**RE: Del Web @ Mirehaven Arroyo LOMR Request
Engineer's Stamp Missing – Not Approved
Hydrology File: (H09D017D)**

Based on the information provided in your LOMR Request received 10/12/17, the above referenced LOMR Request cannot be approved until the following comments are addressed.

HEC-RAS PROFILE

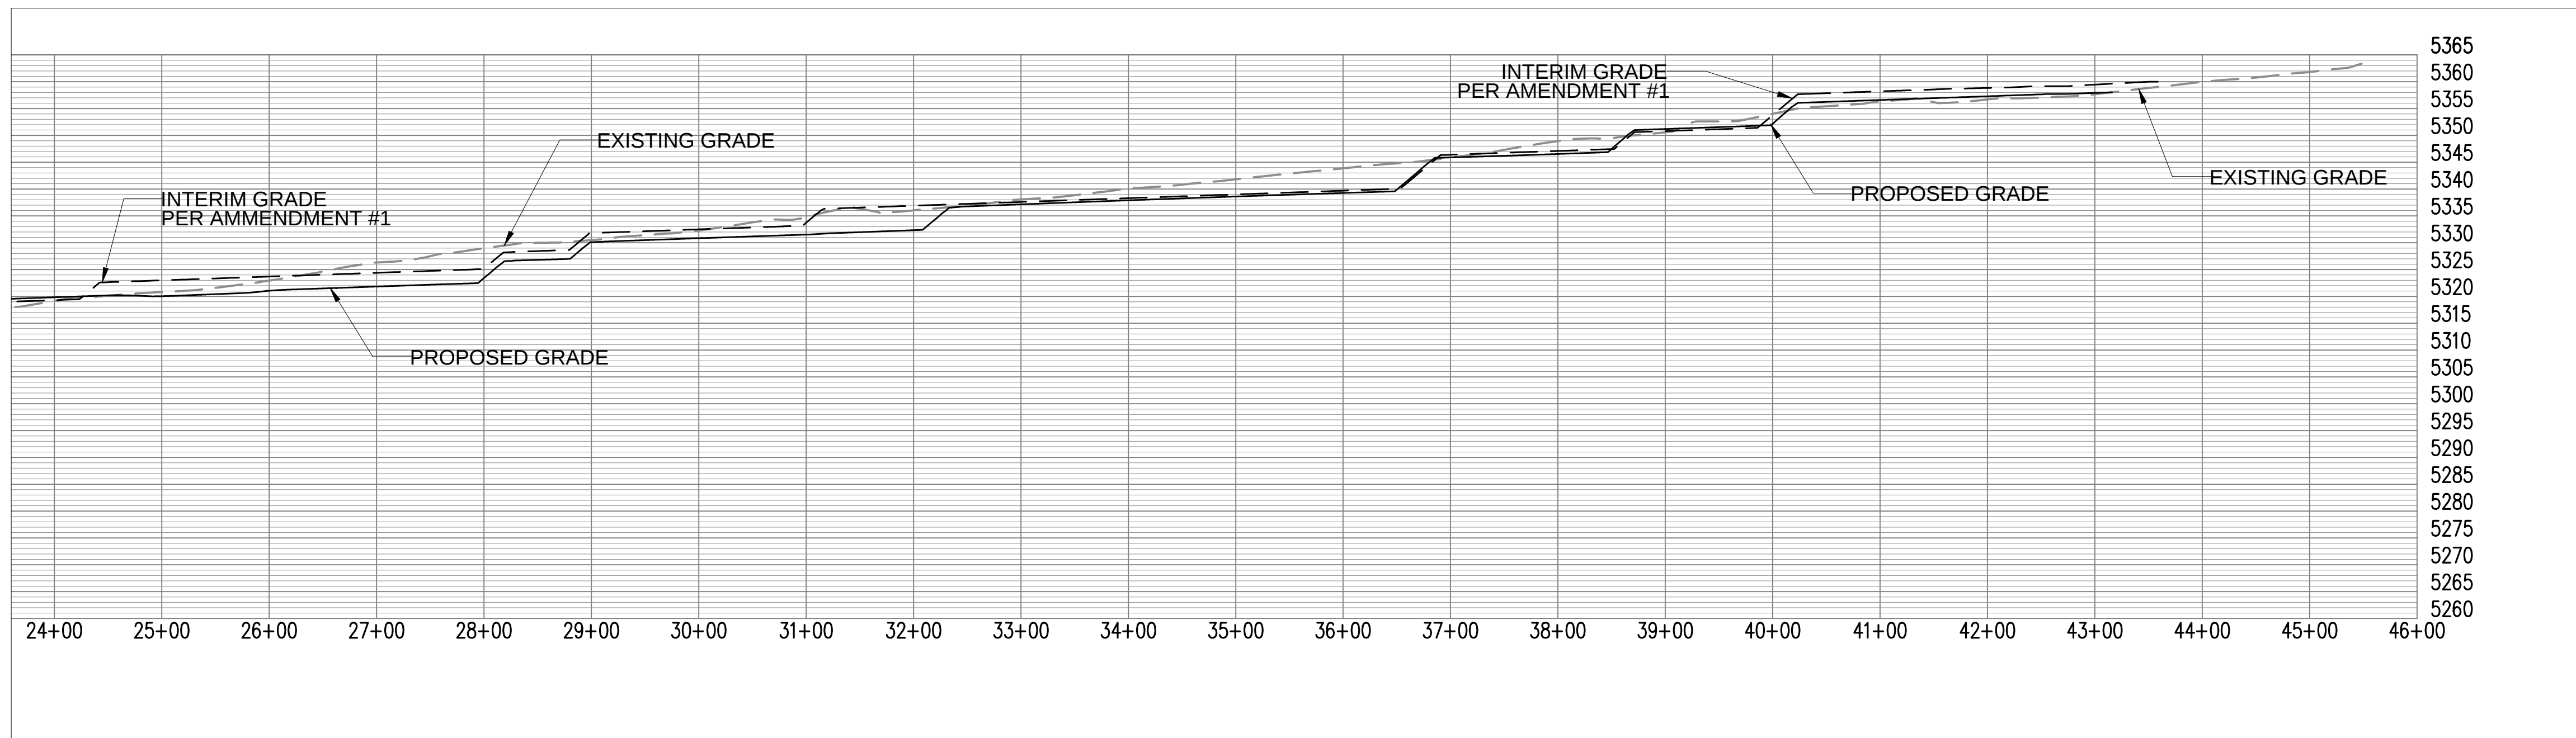
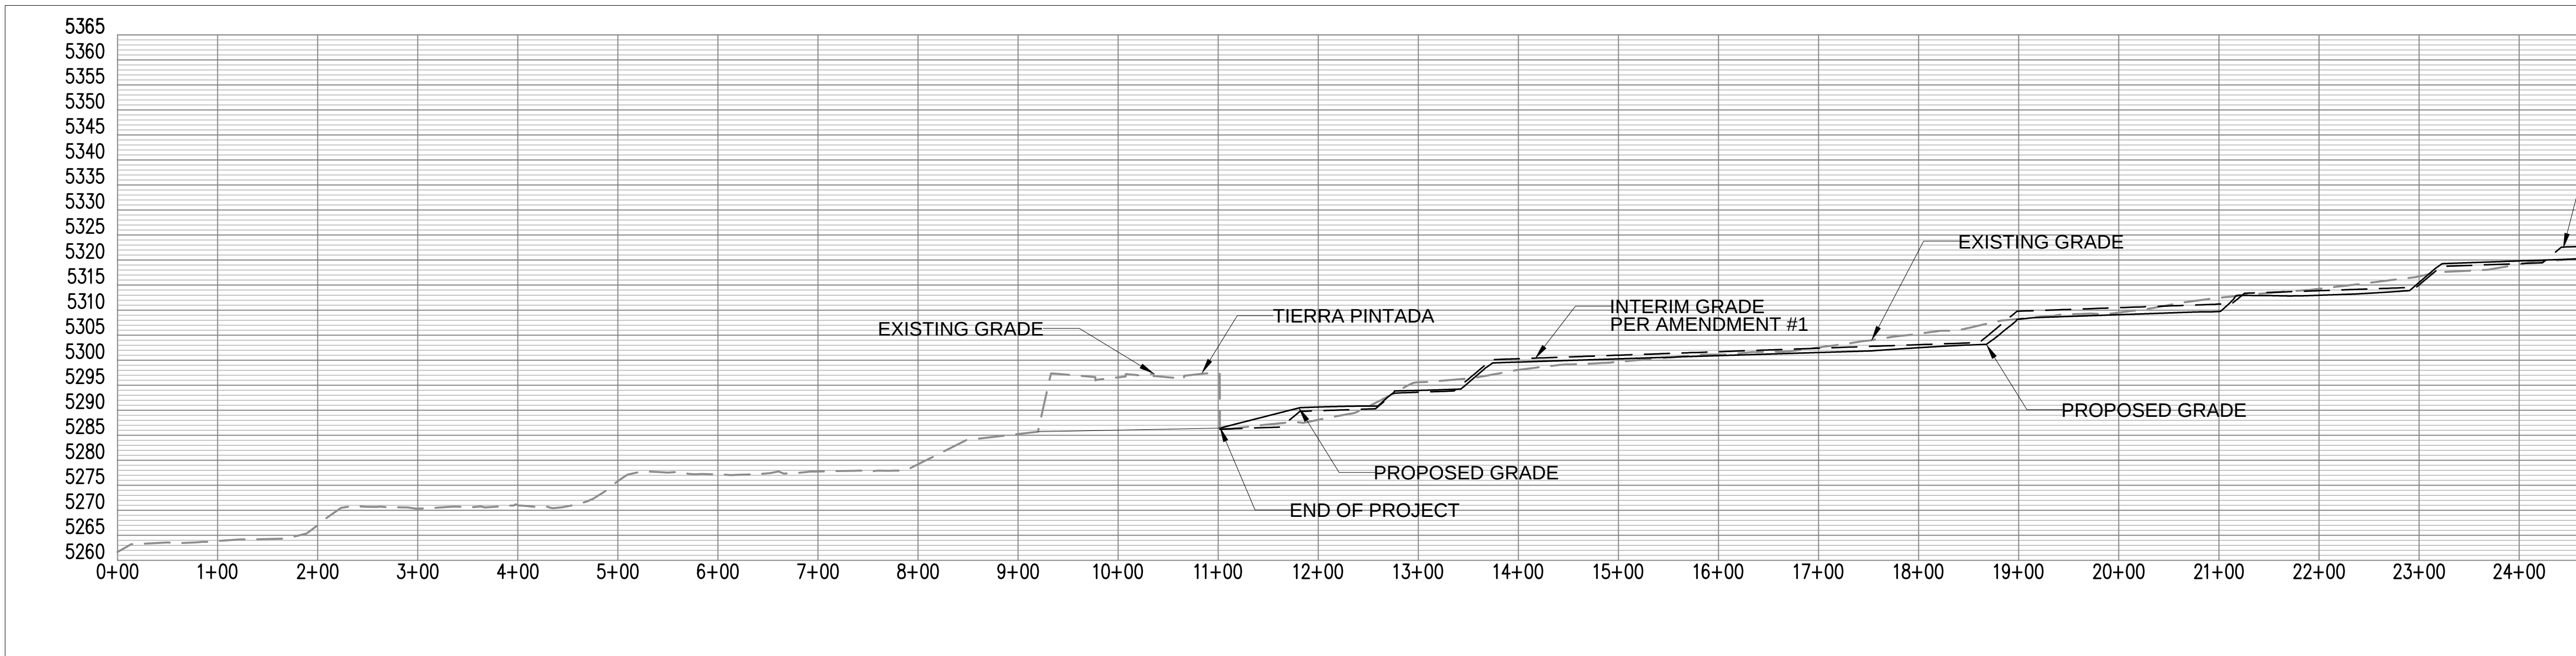
11. The BFE should be based on subcritical depth. Please revise the HEC-RAS model and all profiles and exhibit to reflect the subcritical elevations. There are too many abrupt changes in channel geometry to assume that any portion of the flow is supercritical.

MIREHAVEN ARROYO IMPROVEMENTS PLAN

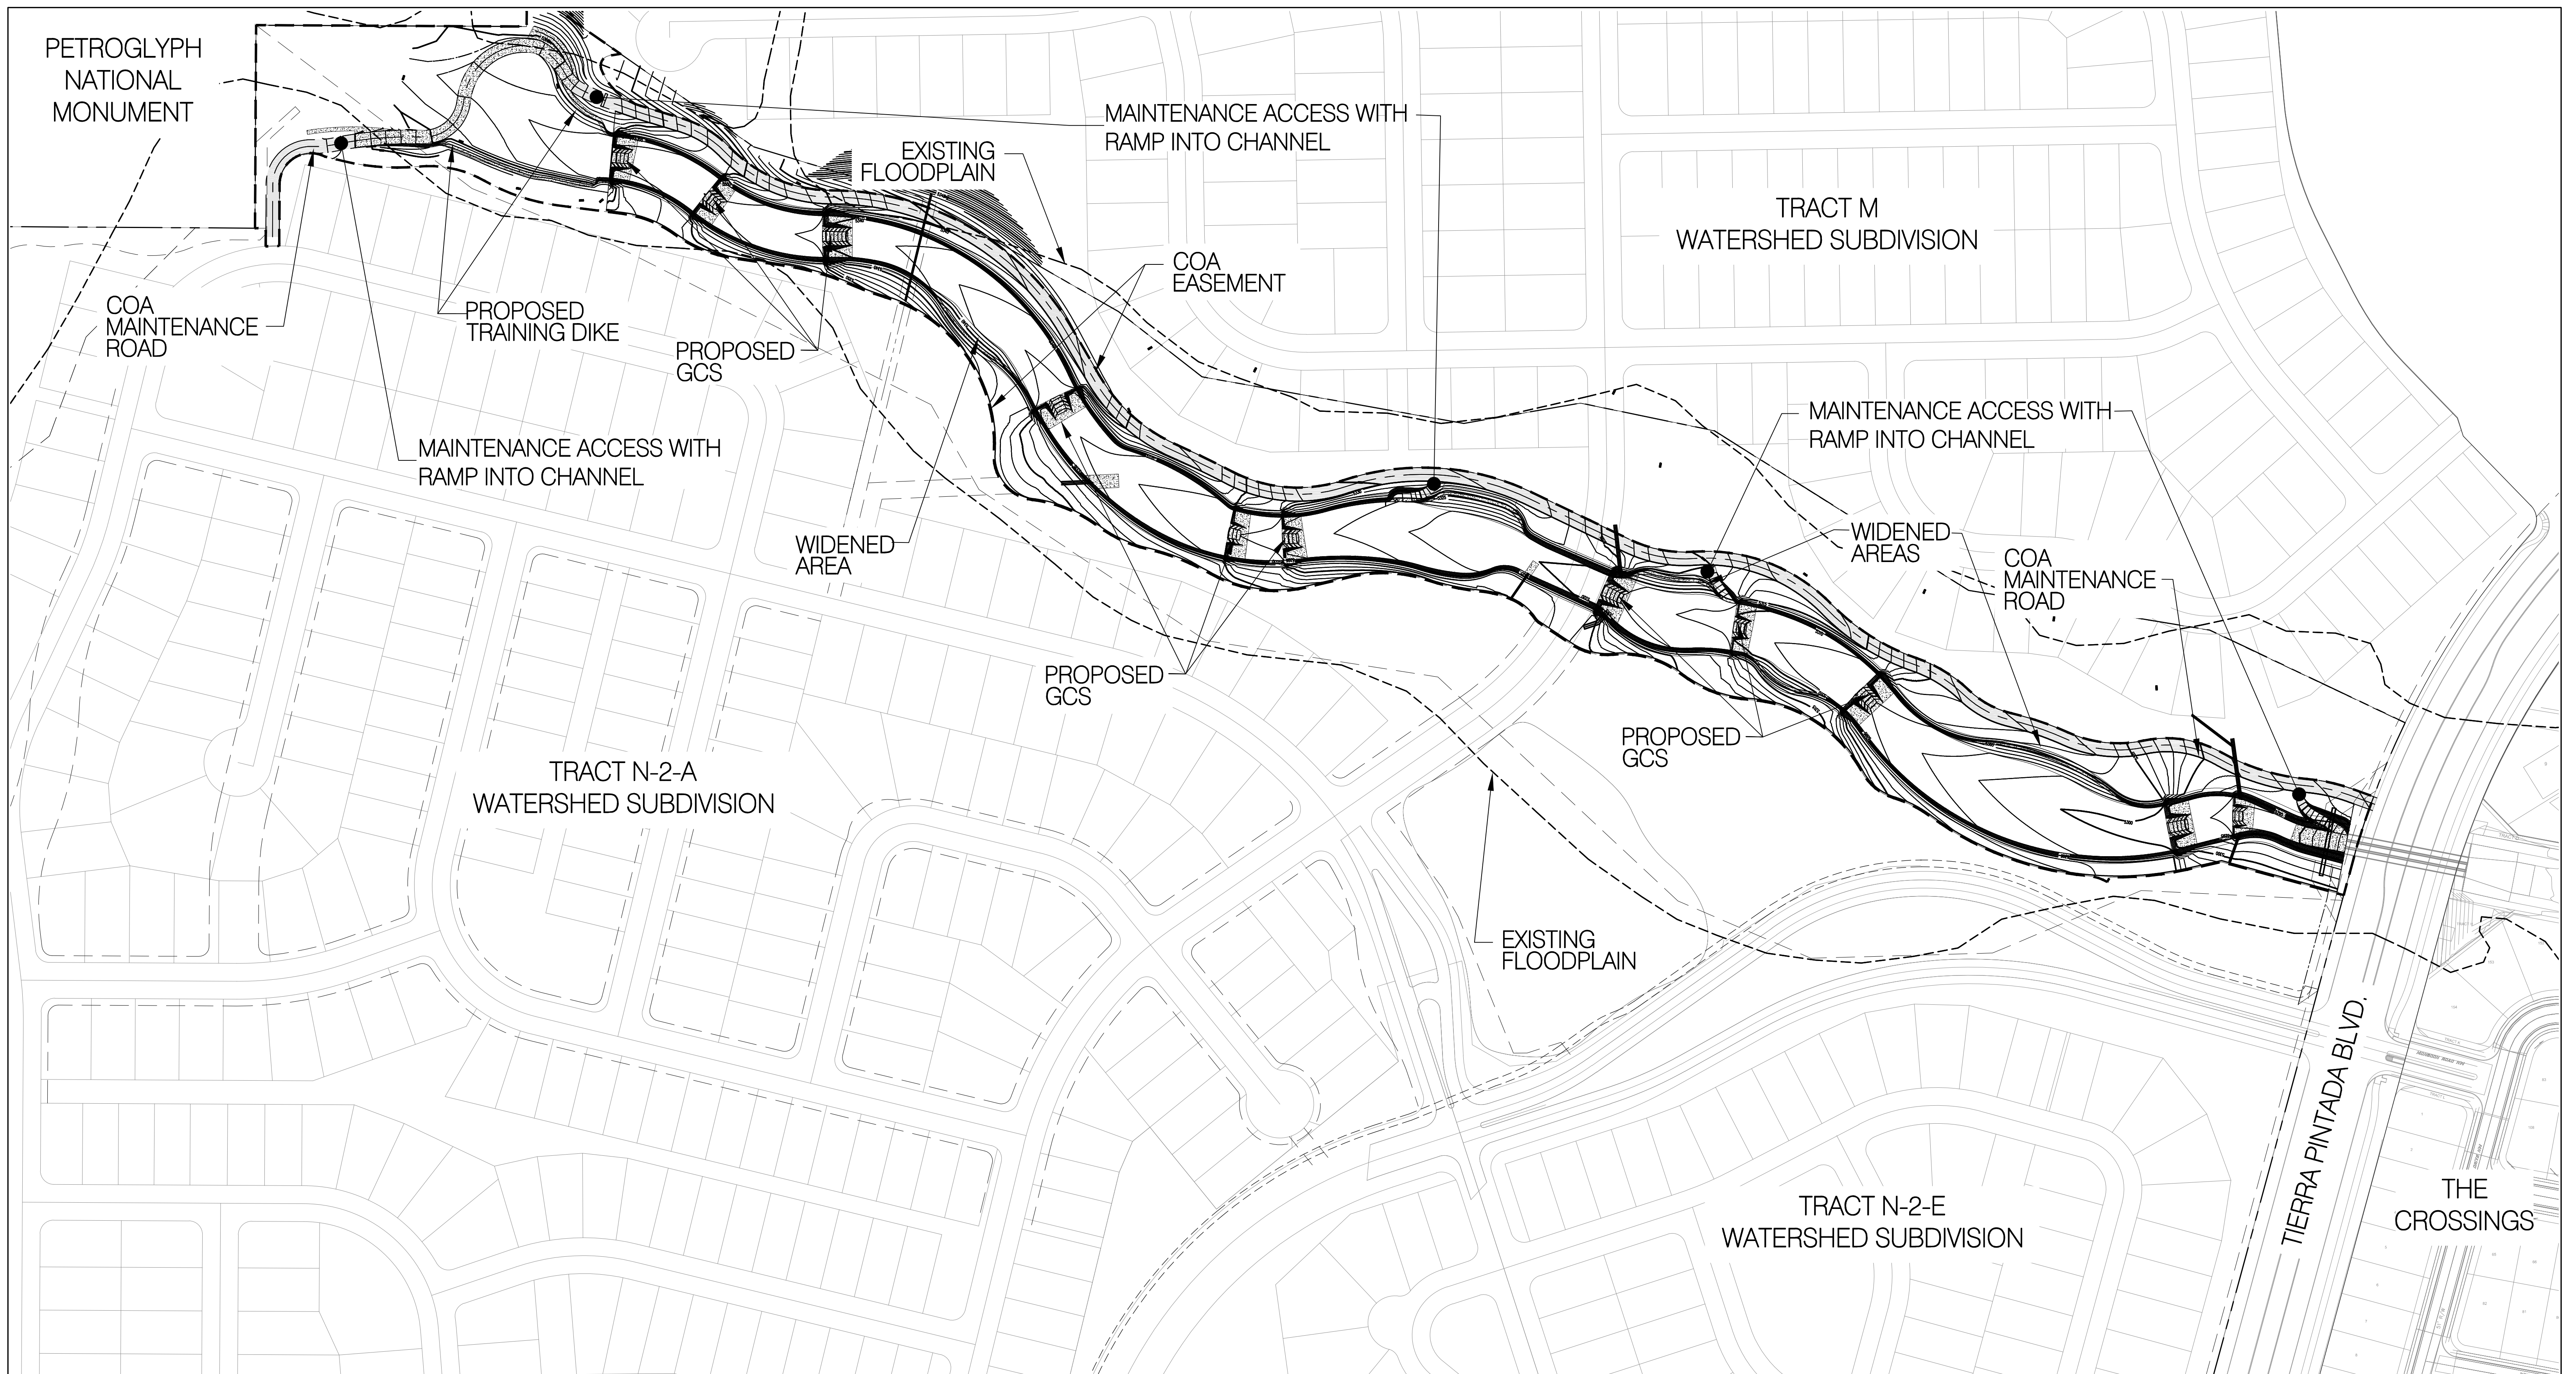
10. The annotated FIRM needs more specific labels added. The portion of the revised floodplain that is contained by the shotcrete bank protection should be changed from an AO zone to an AE zone with BFE contours labeled near the top and toe of each grade control structure. The portion upstream of the shotcrete should still be mapped as an AO zone due to its erosive shifting nature.
